Please ask for: Nicola Moore
Email: nicola.moore@arun.gov.uk
Telephone: Ext 37944
Our Ref: M/83/20/PL
Your Ref:
Date: 6th November 2020

Application for Planning Permission

Development: Demolition of Existing Dwelling house and Replacement with new Dwelling House
Location: 18 Old Point Middleton-On-Sea PO22 7RY

Proposed Ground Floor Site Plan in Context
1:200

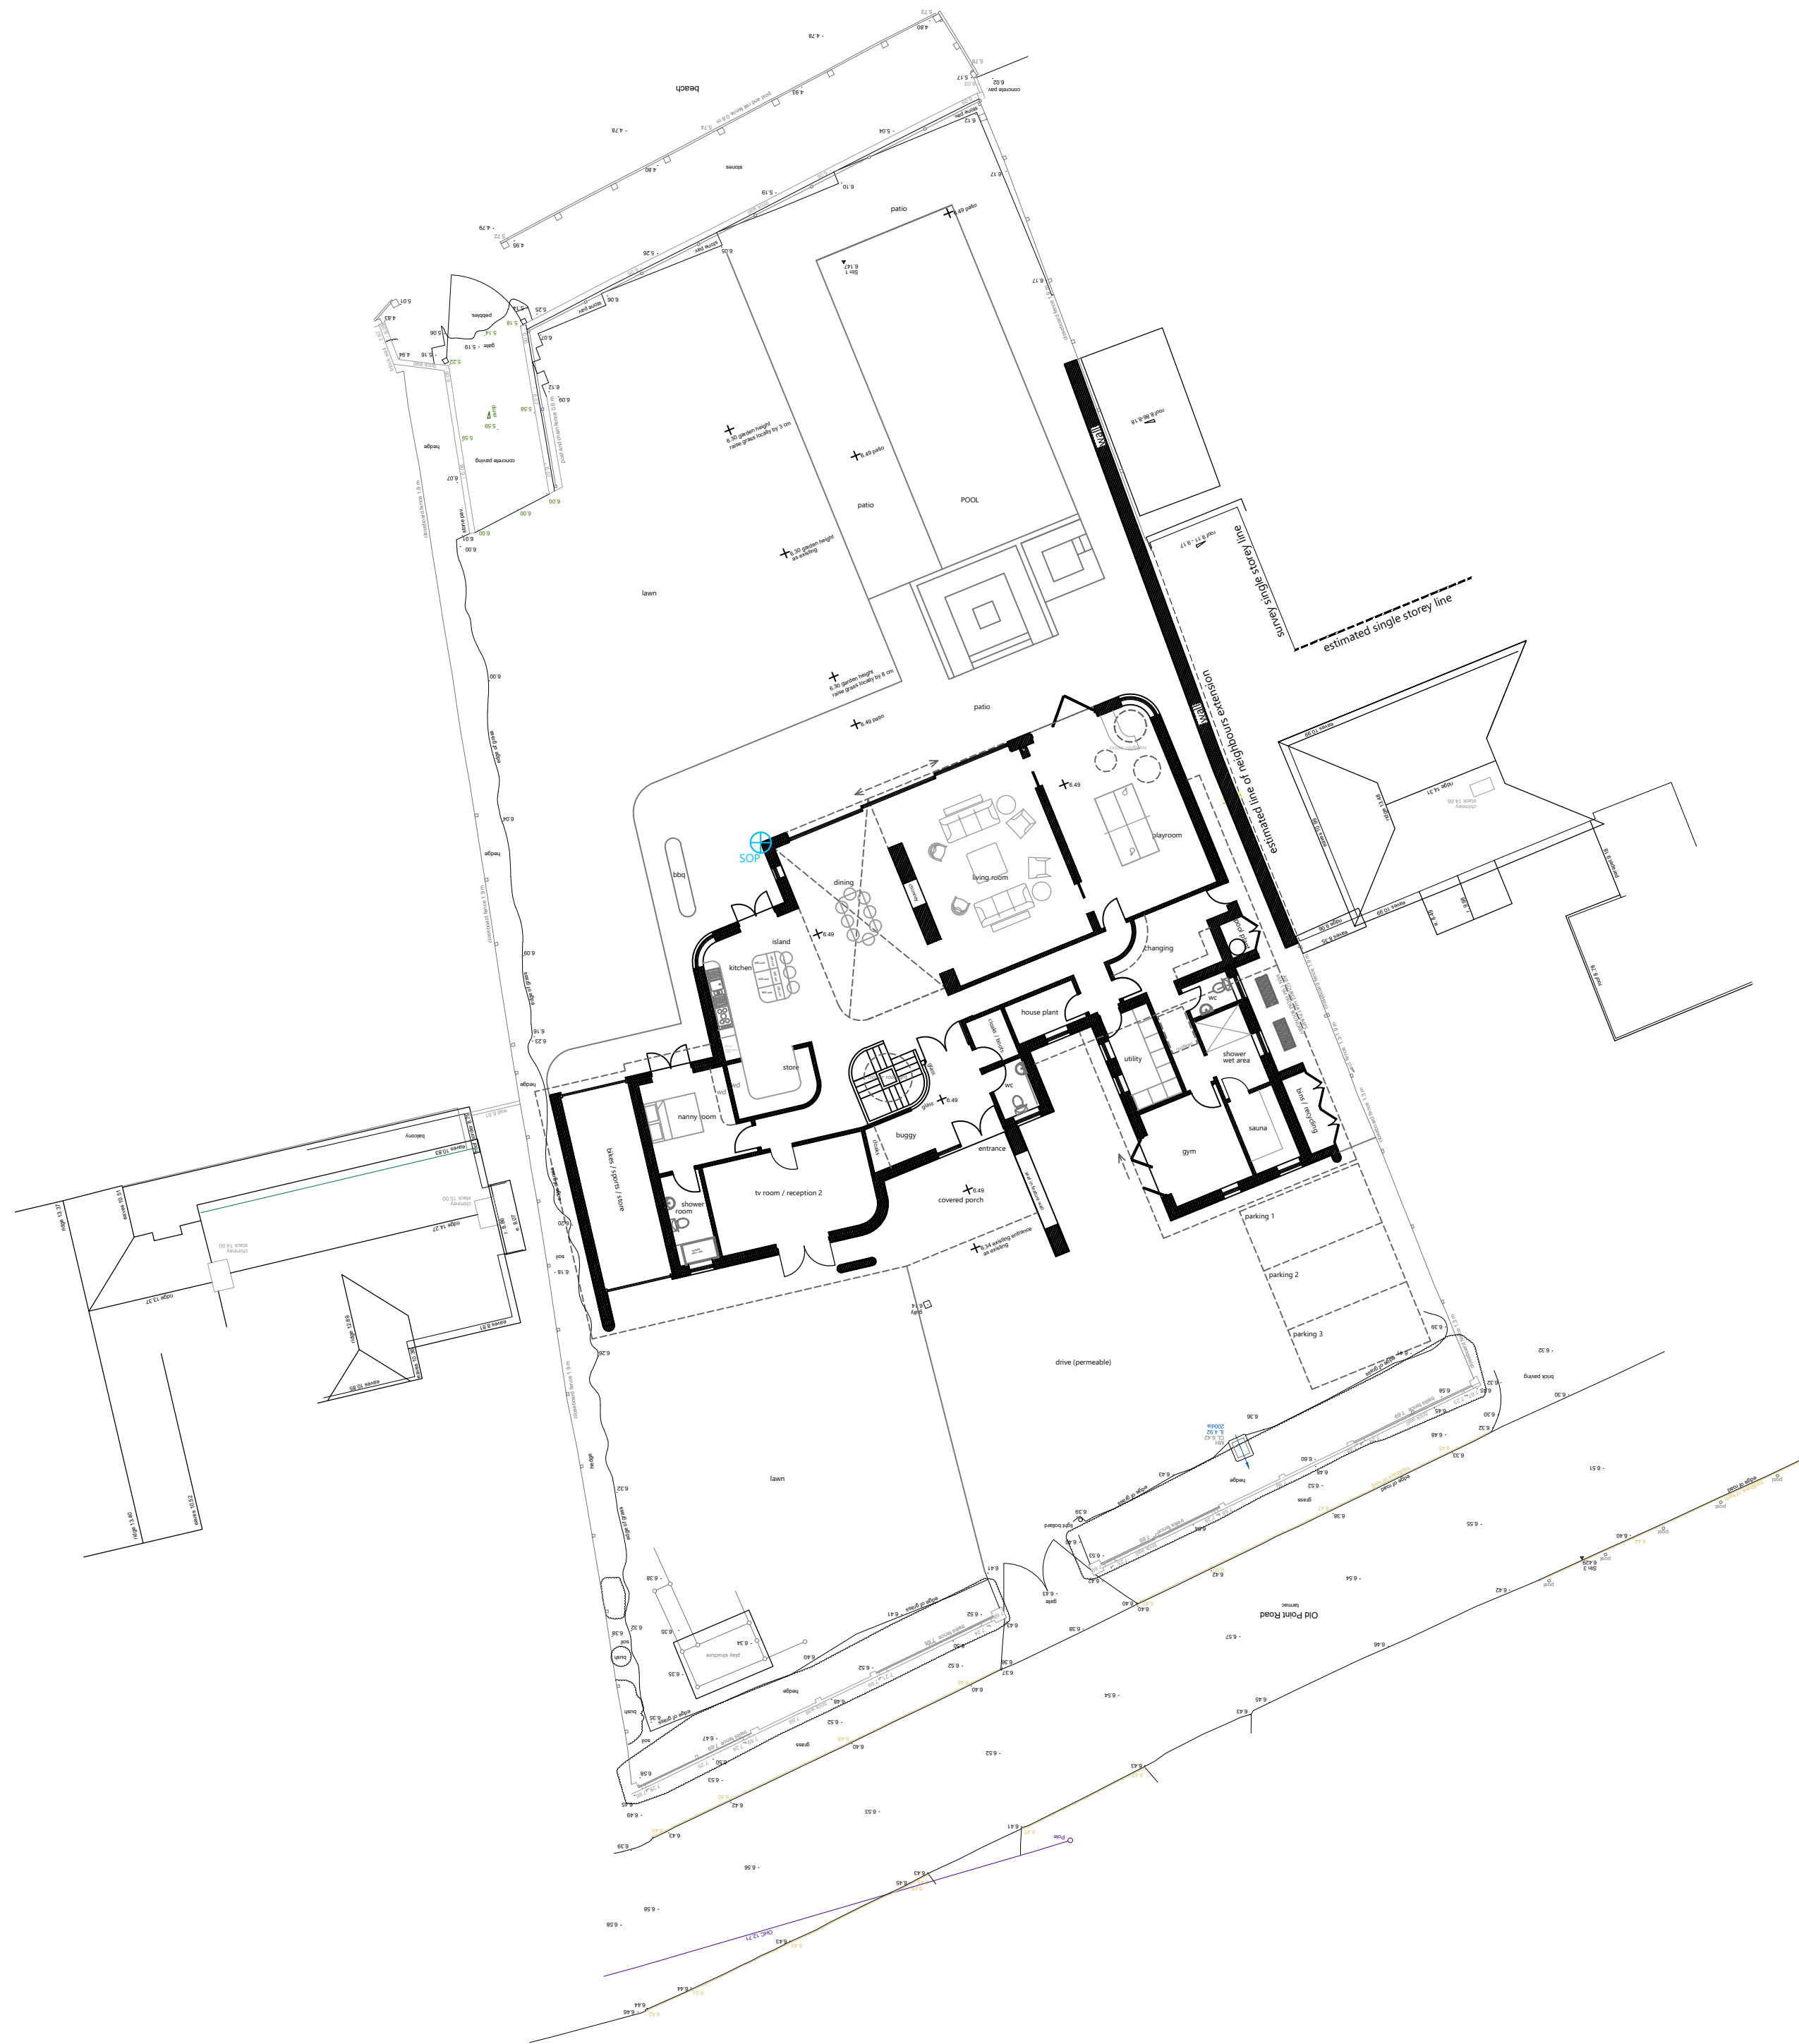
The Proposed West Elevation Dwg No 302 Rev C appears to show 6 windows on the Ground Floor. However, on the Proposed Ground Floor there only appears to be 5. Please check the Ground Floor West Elevation, and confirm or amend accordingly and re submit.
